DRB Application No.: 03-01722 (SBP)	Project # 1003025
Project Name: MERIDIAN BUSINESS PARK	EPC Application No.: Z-92-57
Agent: Claudio Vigil Architects	Phone No.:

**CITY OF ALBUQUERQUE
PLANNING DEPARTMENT
Development Review Board
October 15, 2003 Comments**

RE: Meridian Business Park/SDPBP

DESCRIPTION OF REQUEST: Site development plan for building permit for office warehouse

SHEET SP-1

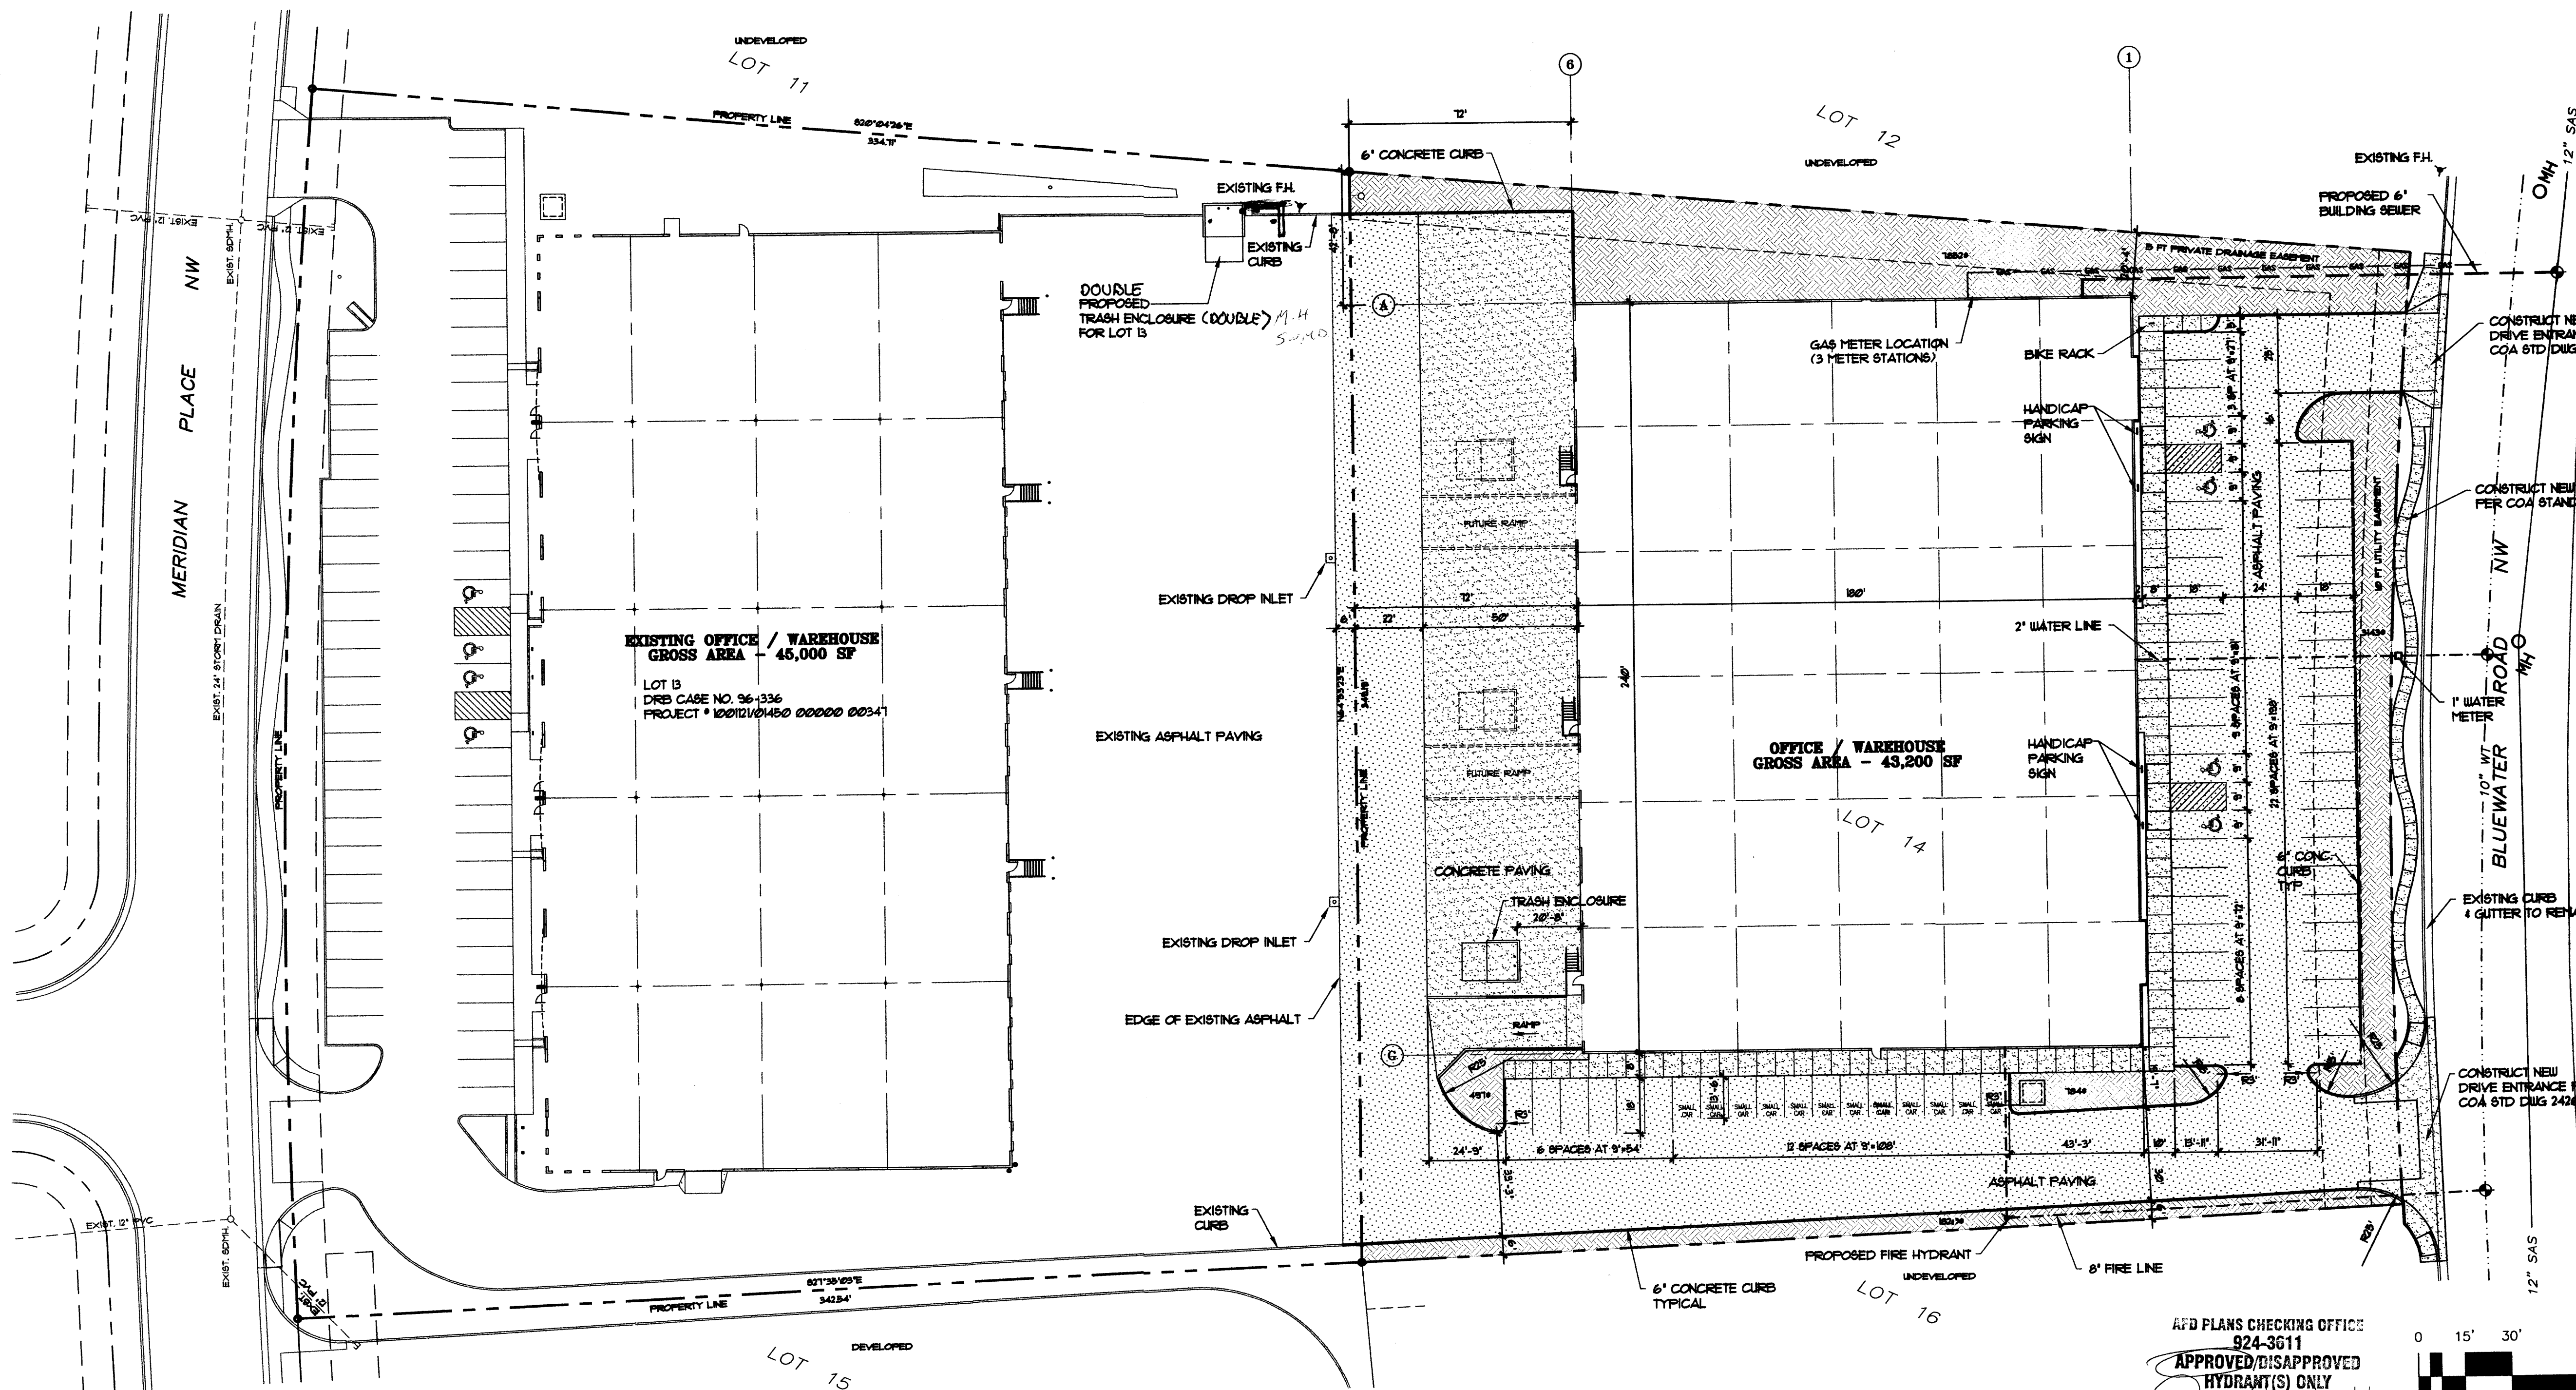
TRANSPORTATION: • SH DRIVE ENTRANCE LOCATION
 • X-ACCESS EASEMENTS
 • POSSIBLE TIS MITIGATION

Be sure the site plan mylar has the correct signature block.

- ① *(SEE) X-ACCESS AGREEMENTS FOR INTERNAL CIRCULATION AND LOADING DOCKS*
- ② *COMPLY WITH DPM ON PARKING STALL TILES USE OF BUMPERS AGAINST DLDS.*
- ③ *DISTANCE FROM PROPERTY LINE FOR ENTRANCE @ SW CORNER (WHAT IS WIDTH?)*
- ④ *WIDTH OF SIDEWALK?*
- ⑤ *CONTRIBUTION OF TCS REQUIREMENTS? (SIGNAL @ INTER/ LOS VENTAS)*

NORTH
LANDSCAPE PLAN
OCTOBER 3, 2003 1"=30'-0"

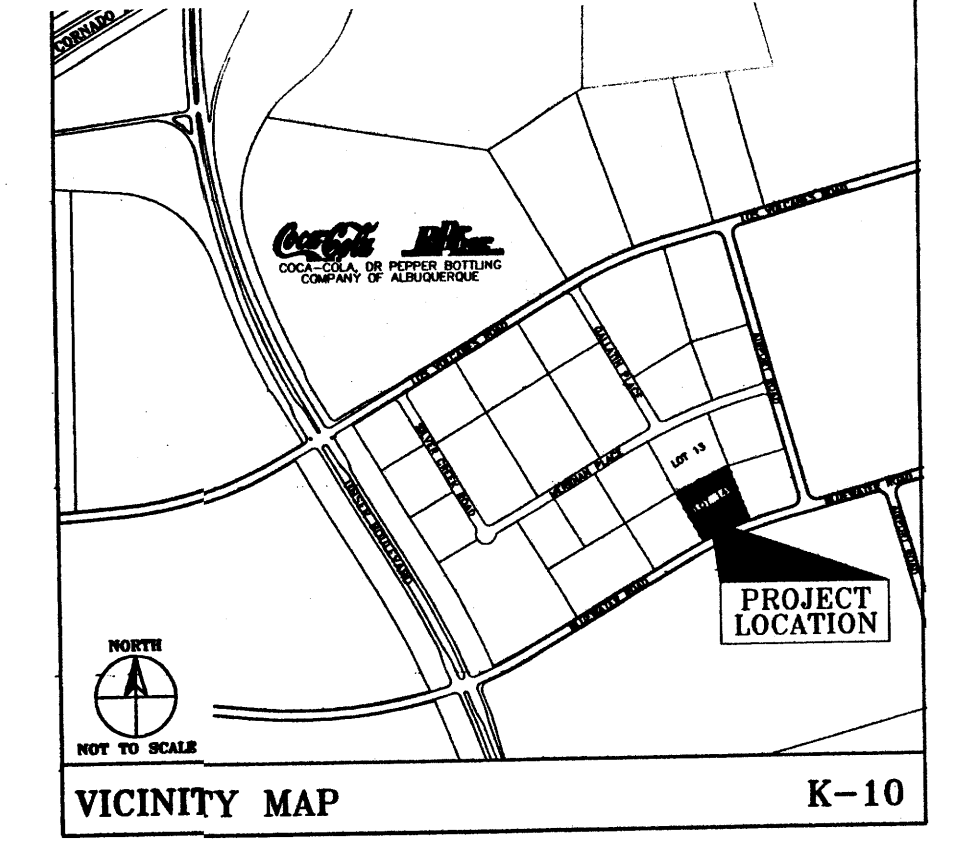
Junipers are no longer permitted on landscape plans due to their high allergen content. Creeping rosemary is sometimes a good alternative.

Austrian Pines are a high water use tree according to the City's Plant List. Please consider another lower water usage alternative.

Where is the sod planned? Sod is on the legend but I didn't see it on the Landscape Plan. Even though the Master Plan talks about 30% sod, it is a huge use of water and, hopefully, unnecessary.

SITE DEVELOPMENT PLAN FOR BUILDING PERMIT ELEVATIONS

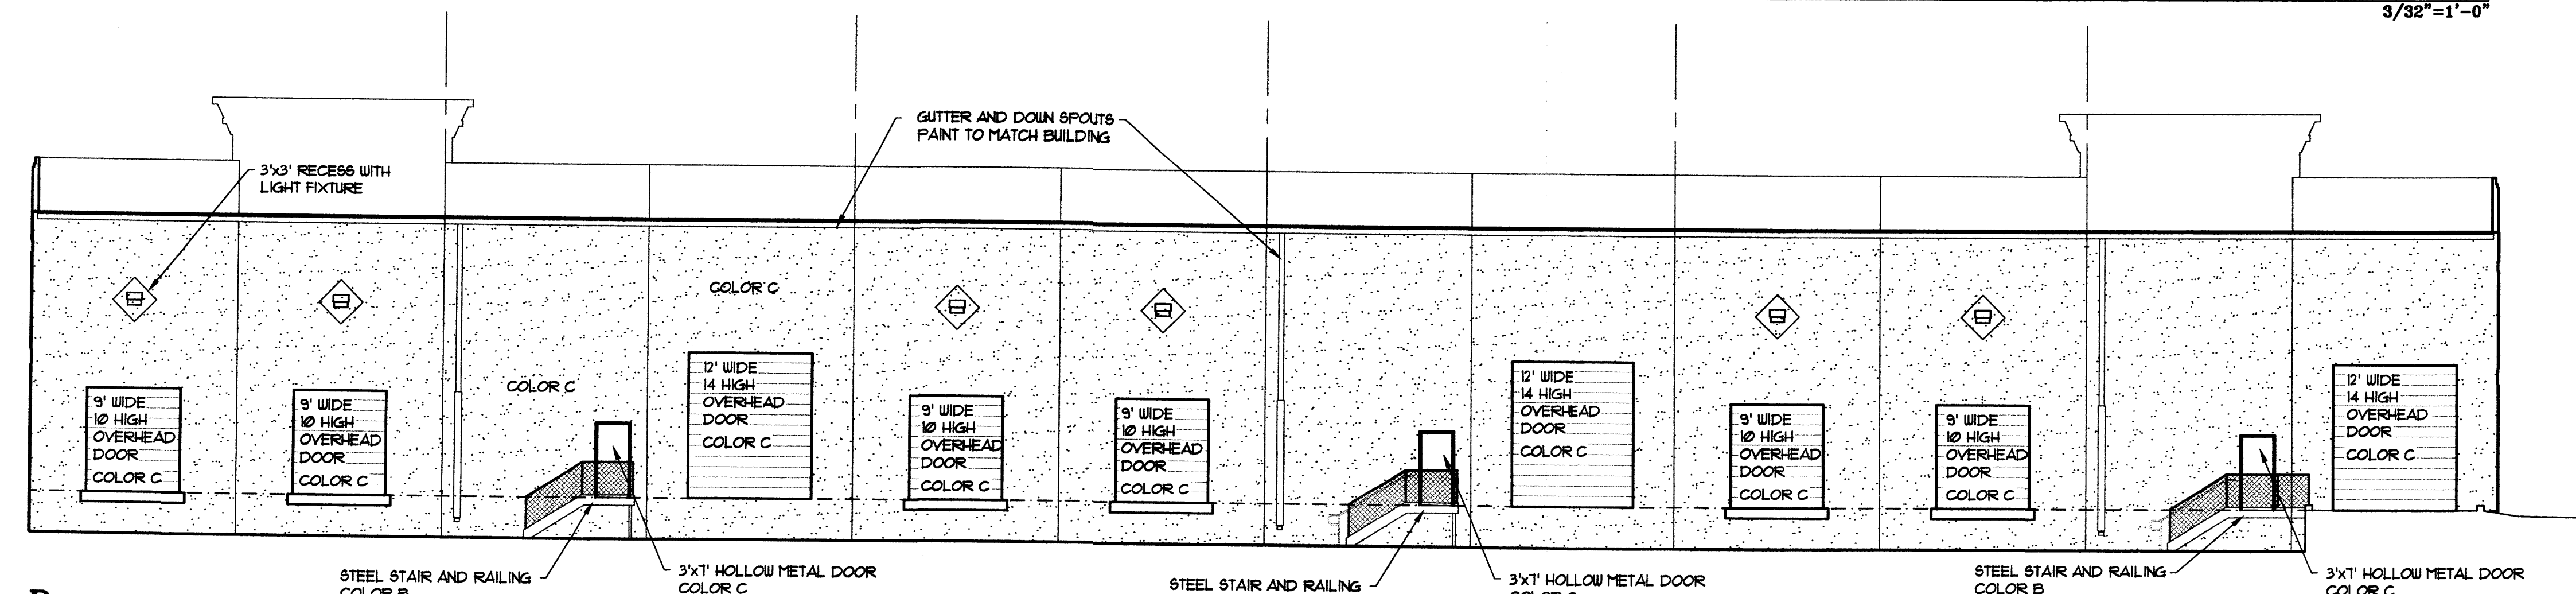
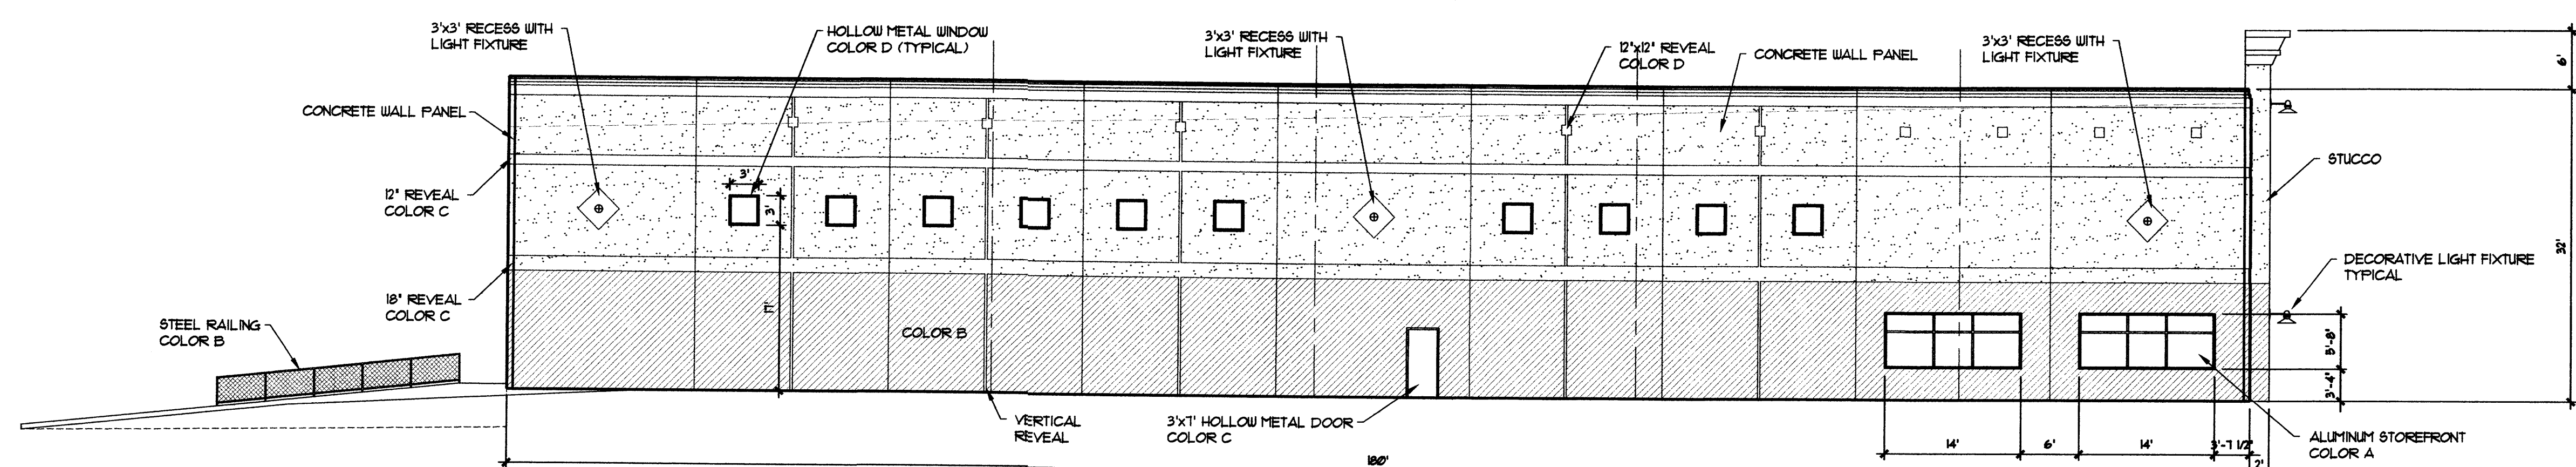
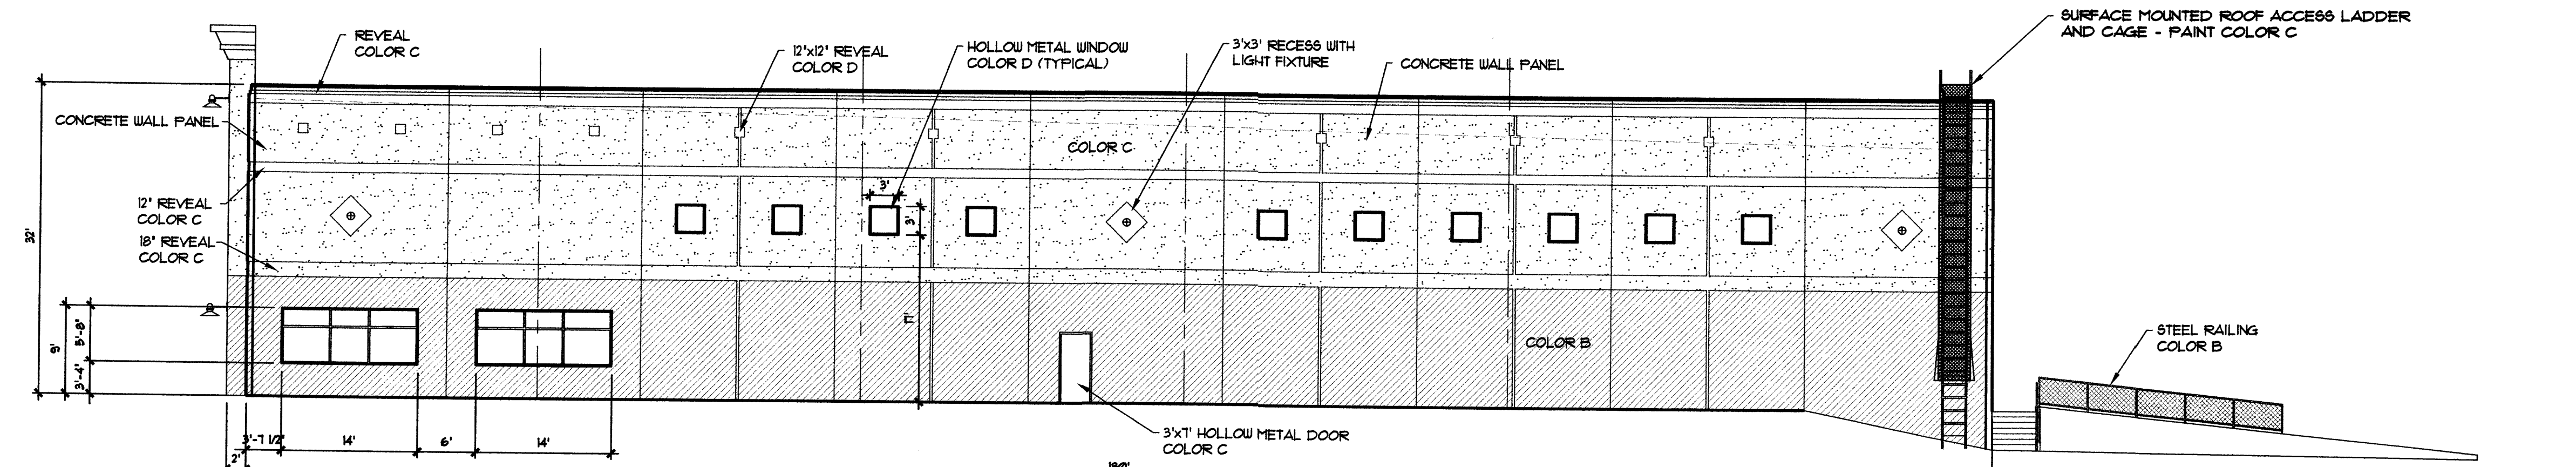
Is the only sign to be building mounted on the façade? If a free standing sign is planned, the elevation is needed on the site plan.
